CITY OF PORTLAND, MAINE

PLANNING BOARD

June 2nd, 2014

Project Name: **Six Unit Commercial Building**
Project ID: 2014-016 CBL: 296-A006001
Address: 421 Warren Avenue, Portland
Joint Applicants: PH Warren Avenue, LLC
Planner: Jean Fraser

REV	DATE	DESCRIPTION	REVISIONS
3	07.03.14	FINAL PLAN SUBMISSION TO CITY PER CONDITIONS OF APPROVAL	
2	04.17.14	FINAL PLAN SUBMISSION TO CITY	
1	02.10.14	SUBMITTED TO CITY OF PORTLAND

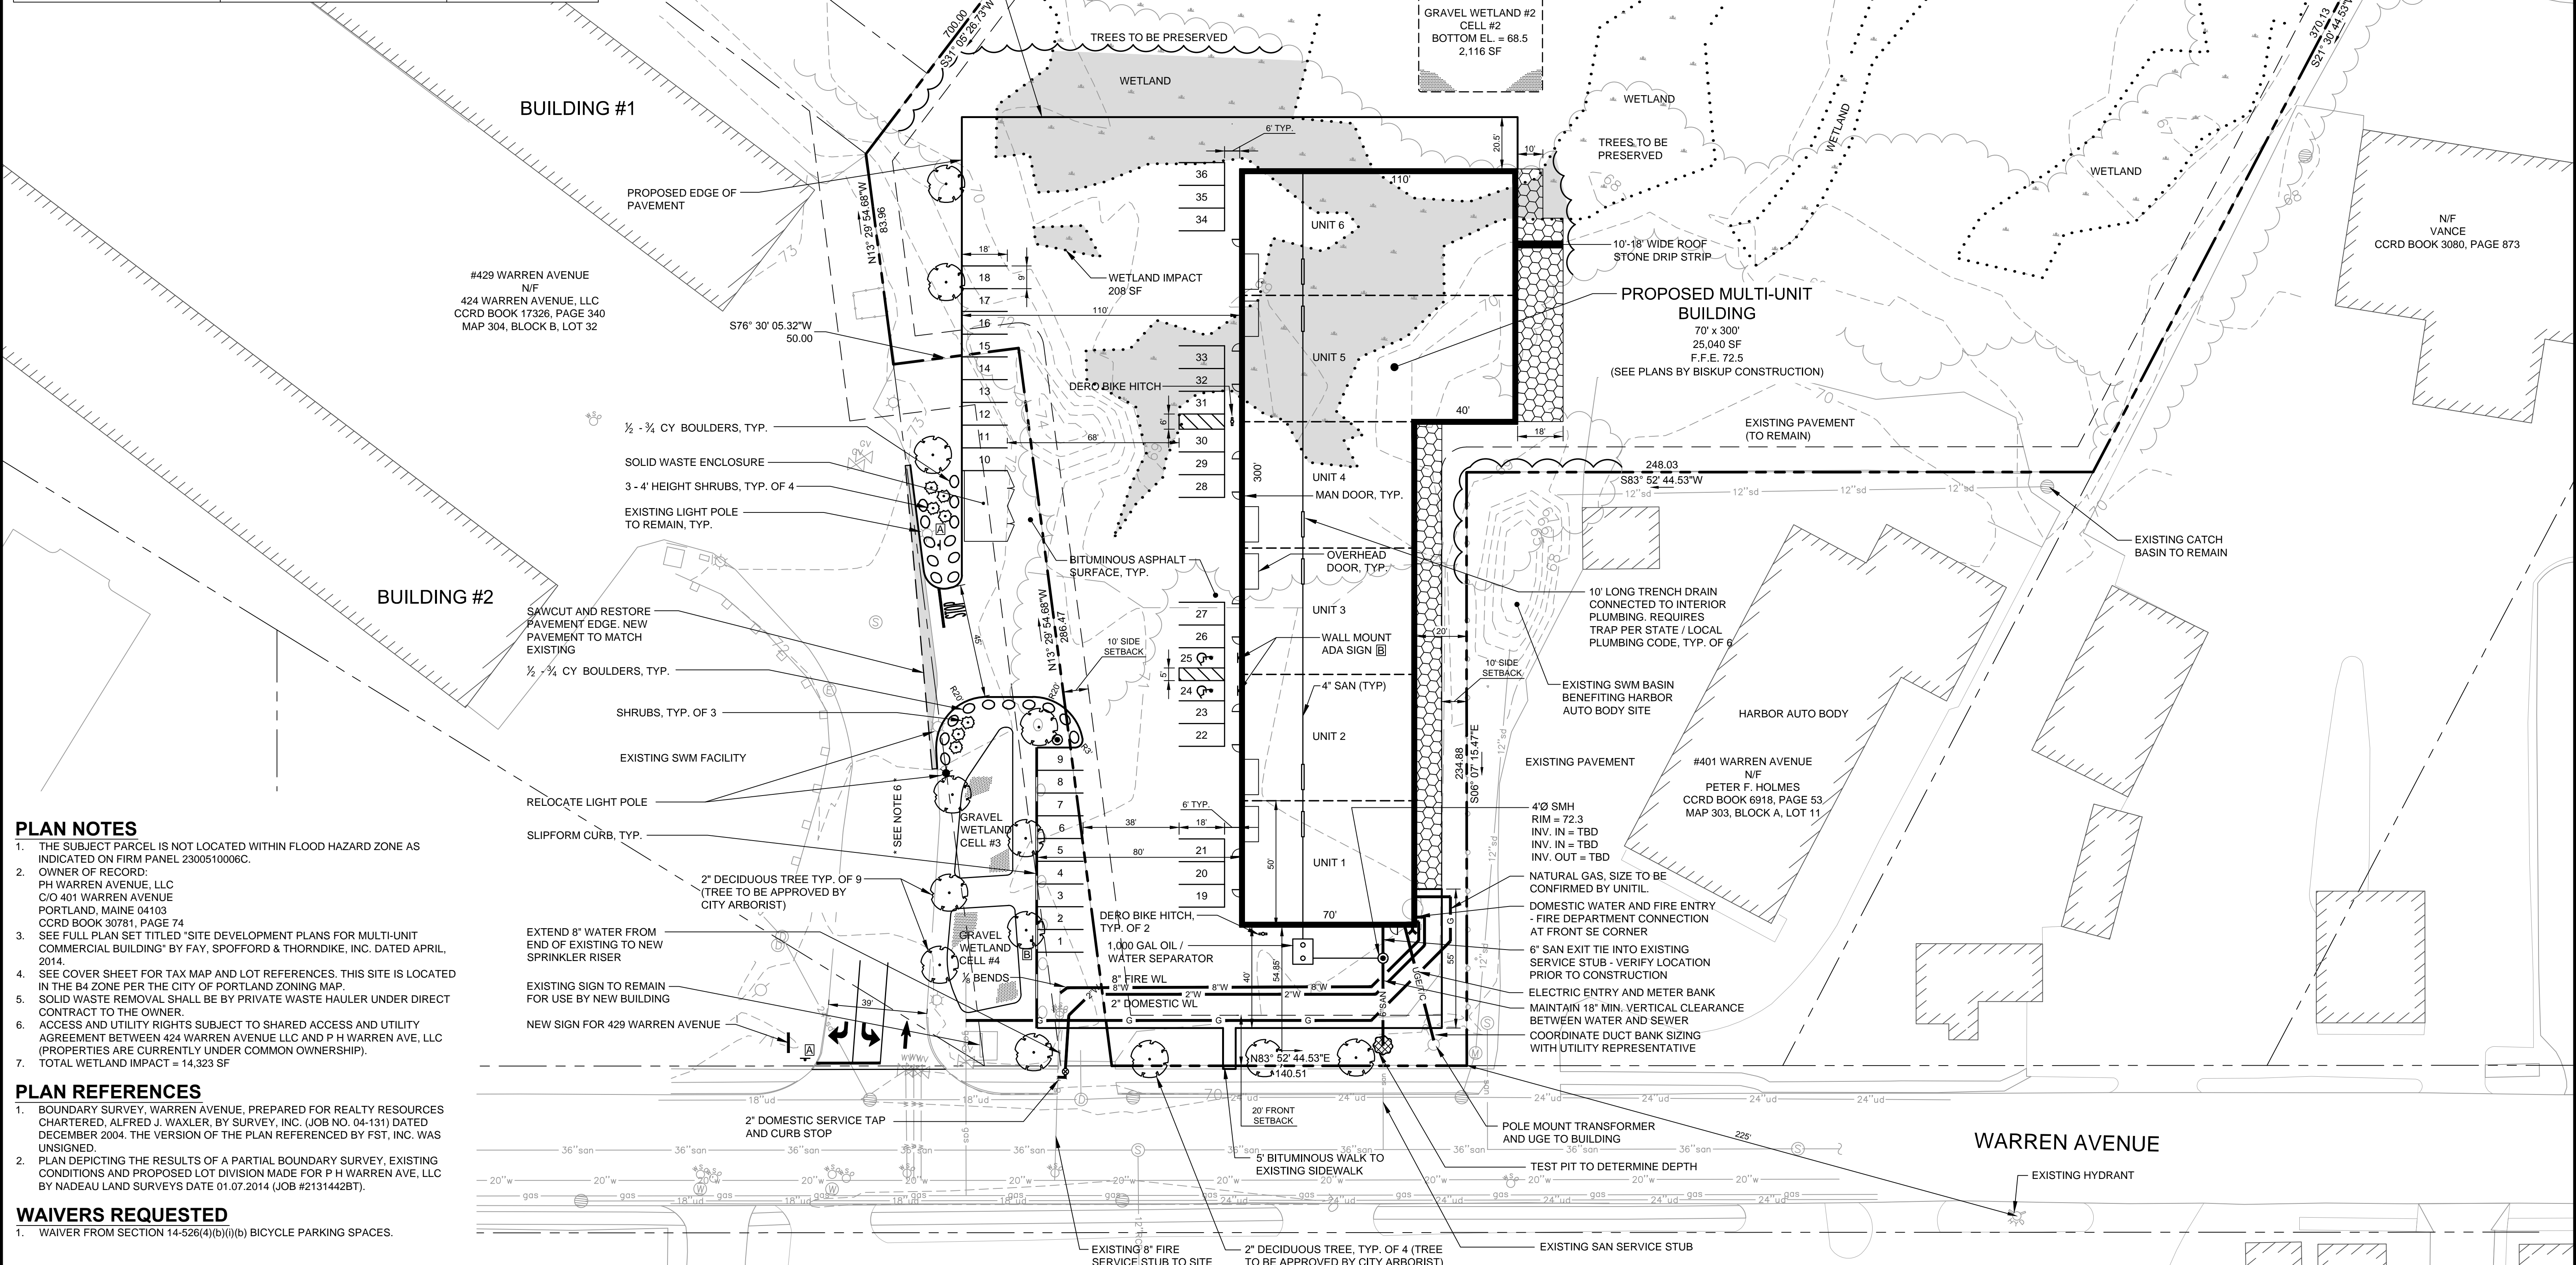
- vii. That the applicant shall close the existing curb cut on Warren Avenue (east of the joint access from Warren Avenue into the site); install three signs along the back of the property where the asphalt ends stating: DO NOT DUMP - IMPAIRED WETLANDS; and shall mark with paint the pedestrian walking area in front of the building and between the building and Warren Avenue sidewalk; all prior to the issuance of a Certificate of Occupancy; and

The revised proposals include the pedestrian connection from the new building to the Warren Avenue sidewalk, but have not indicated the painted marking for the pedestrian route along the front of the building and across to the pedestrian link. A potential condition of approval has been included, at Mr Errico's recommendation, to include the painted markings for the pedestrian route.

The site plan (Plan P6) does not specifically call out snow storage. The proposed paved area is likely to provide adequate area for snow storage, but the proposed wetland cells, swales and erosion control features about the paved area and a Snow Storage Plan is required to ensure that these areas are not used for snow storage. A potential condition of approval requests that snow storage areas be shown on the requested Landscape Plan.

The applicant has agreed to close this curb cut in the submitted narrative (Attachment L) but it is not shown on the plans. A suggested condition of approval requests this be shown in the site plan in Plan P6.
